**From:** [Mau, Russell E \(DOH\)](#)  
**To:** [Jeremiah Cromie](#)  
**Cc:** [Holly Erdman](#); [Smits, Brenda M \(DOH\)](#)  
**Subject:** RE: SP-23-00002 Mills-2 - Notice of Application  
**Date:** Friday, May 19, 2023 6:54:43 AM

The Department of Health (DOH) Office of Drinking Water (ODW) has reviewed this application, generating the following comment(s):

MILLS-2 SHORT PLAT

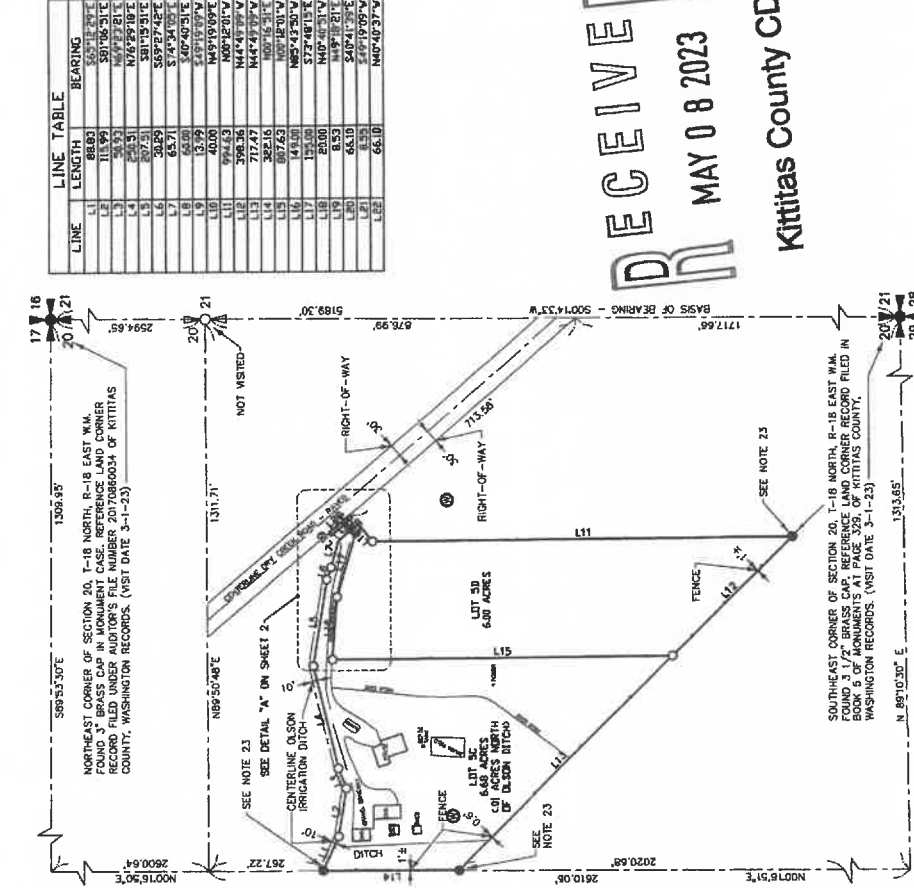
1. For drinking water, the short plat to subdivide a single lot and create 2 lots appears to meet the definition of “project”. For a “project”, any and all groundwater extractions need to be evaluated as a singular total – as an example, if exempt wells are proposed, then the extractions for any or all wells can only be a single exempt well limit. The applicant should consult with Ecology to confirm.
2. The applicant should also contact Kittitas County regarding any water rights needs.
3. The use of a single well serving two homes or 2 individual wells serving each respective home would not constitute a public water system. However, the applicant should contact Kittitas County Health regarding any specific well installation regulatory requirements.
